Manorwood Homes

Lince Lane,  
Kirtlington

Project Reference: 2207-015/TN/02

Technical Note

SCALE: 1:500	DATE: 02.09.22	DRAWN: TW	CHECKED: DF	APPROVED: DF
JOB NO: 2207-015	DRAWING NO: VS01	REVISION: A

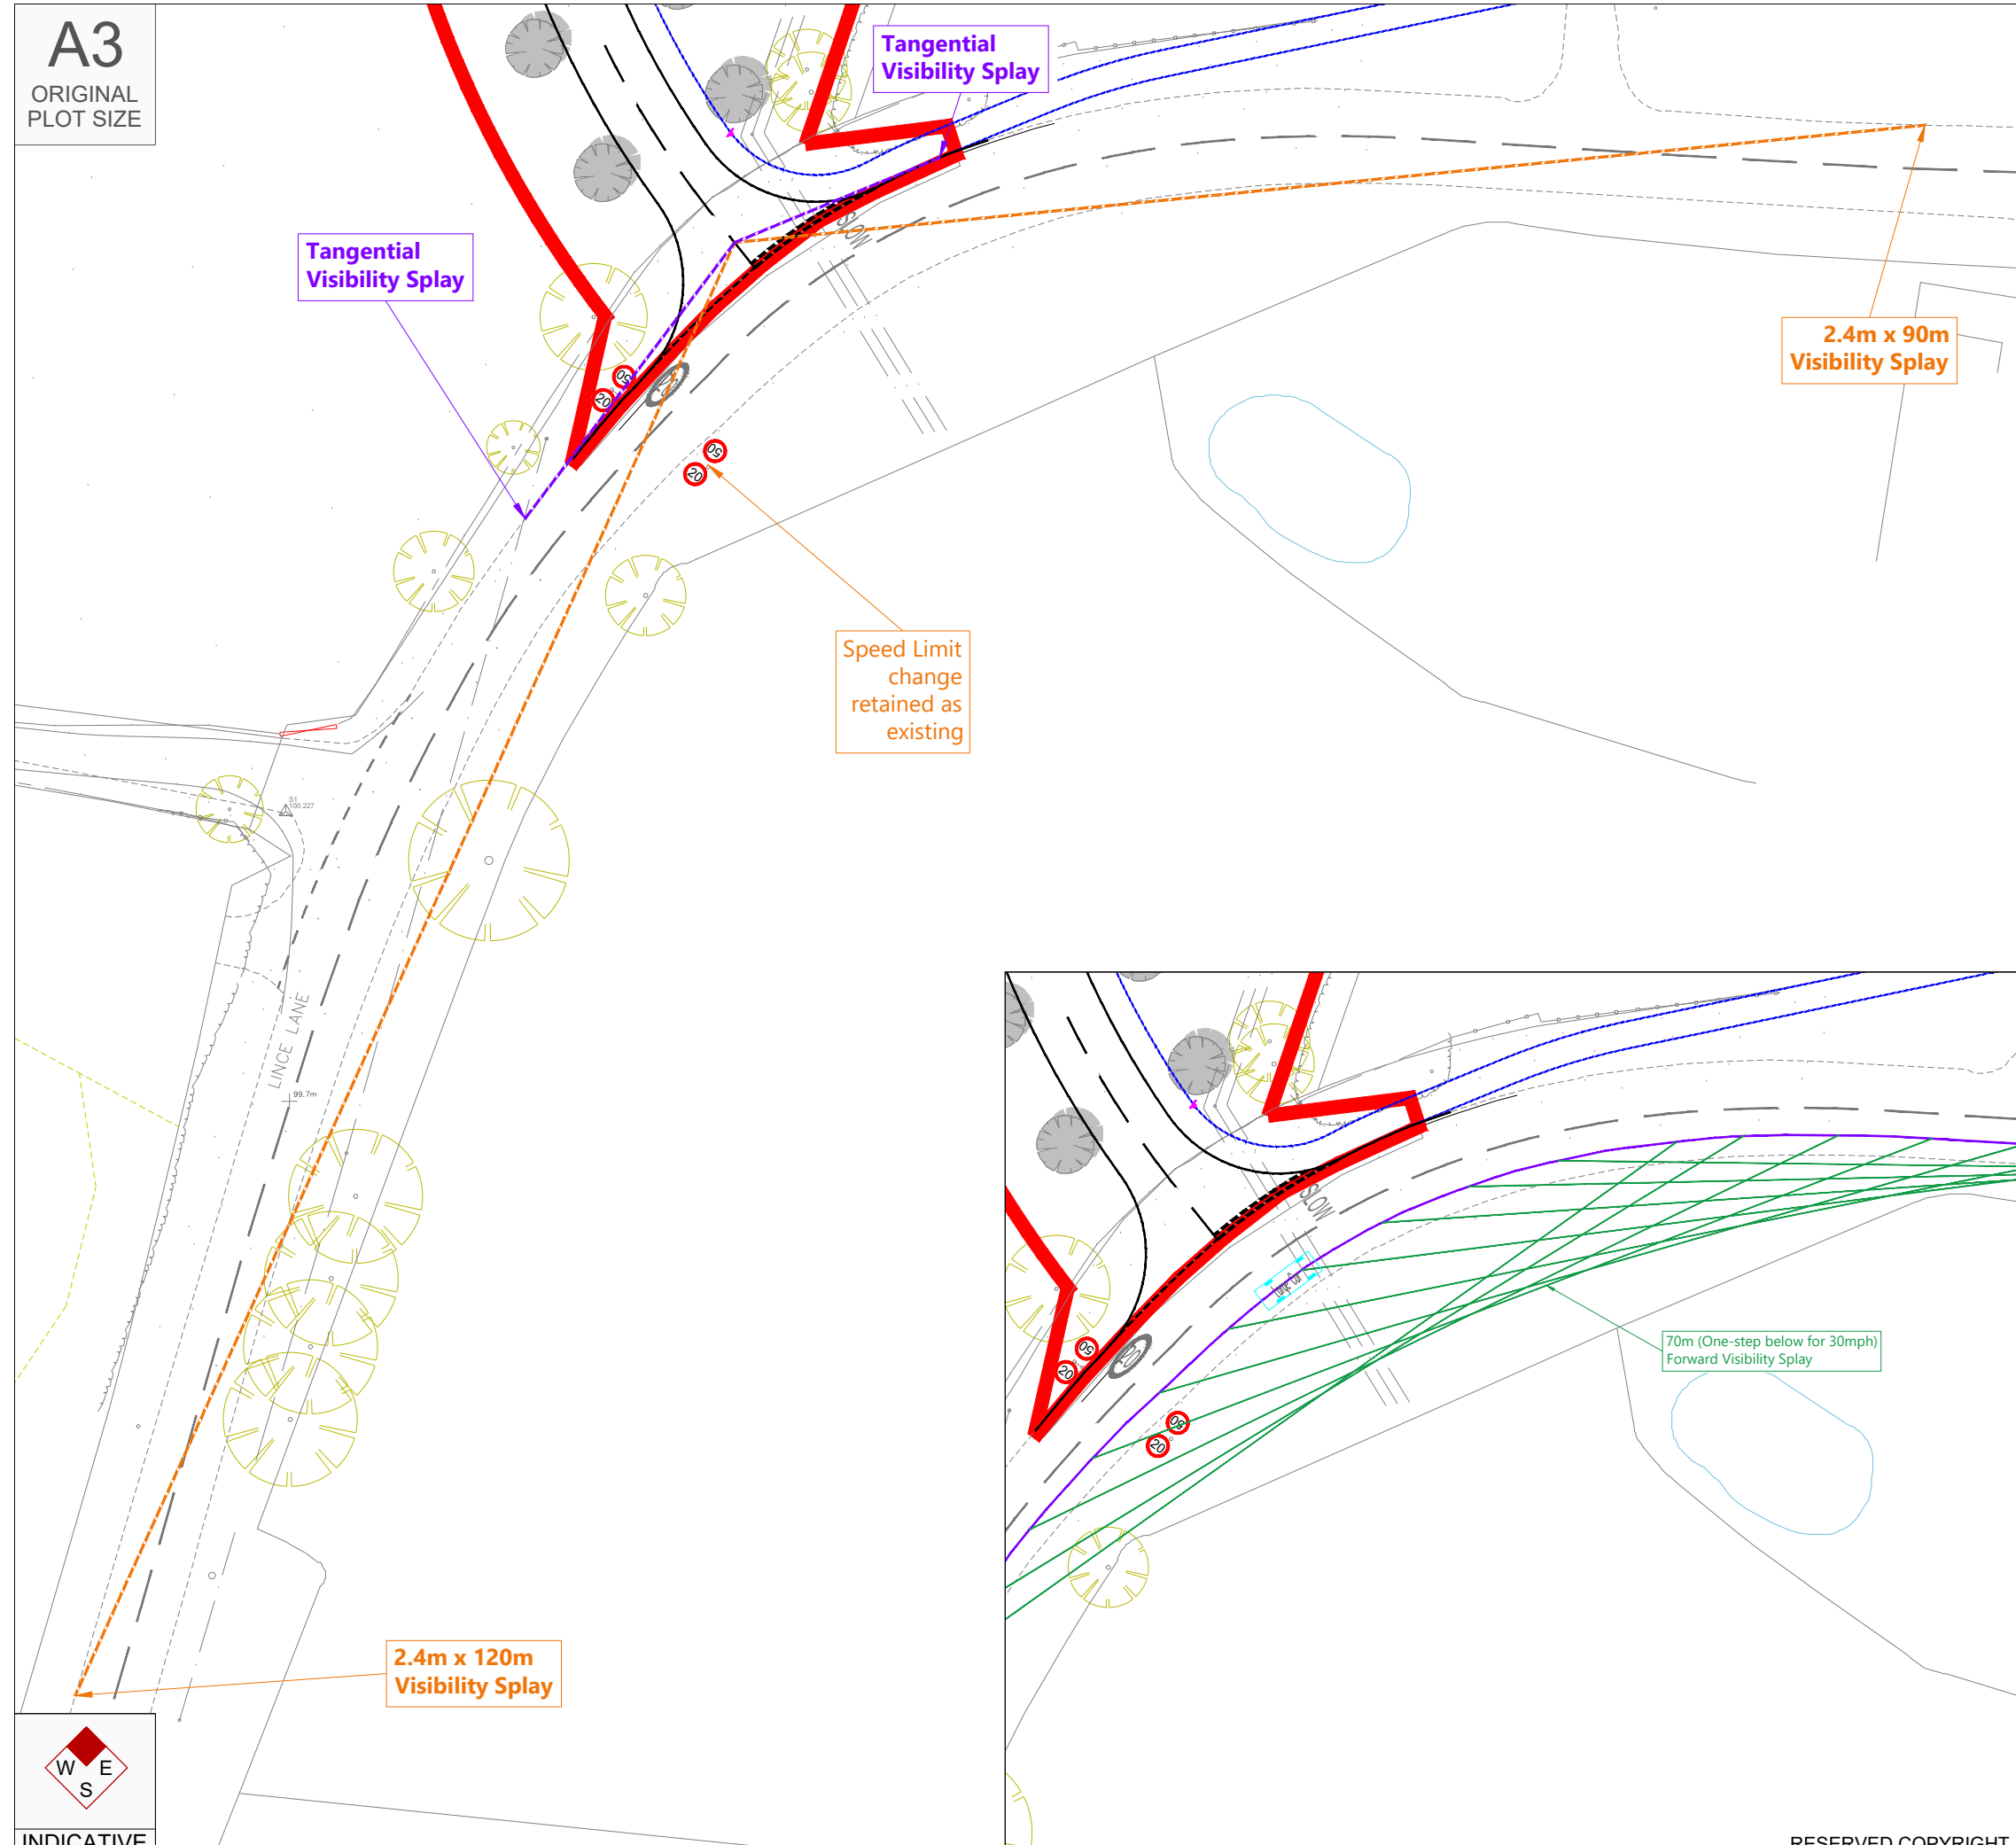
- 2.9 The 85<sup>th</sup> percentile speeds recorded in the traffic survey have been used to calculate the Stopping Sight Distance (SSD) of vehicles travelling in each direction. Based on the SSD calculation<sup>3</sup> the visibility splays required at the proposed site access junction are 76m to the south (northbound vehicles) and 80m to the east (southbound vehicles).

- 2.11 The visibility splay of 2.4m x 120m to the south is in accordance with requirements set out within CD109 of the Design Manual for Road and Bridges (DMRB), which requires a minimum visibility splay of 120m for a 50mph road<sup>5</sup>. The visibility splay of 2.4 x 90m to the east is also in accordance with requirements set out within CD109 of the DMRB, which requires a minimum of 90m for a road with speeds of up to 40mph<sup>6</sup>.

- 2.12 The visibility splays demonstrated in **2207-015 VS01(A)** therefore exceed the visibility splays required for the observed vehicle speeds. As such, it is not considered necessary to implement an extension of the 20mph zone as a direct requirement of the proposed development.
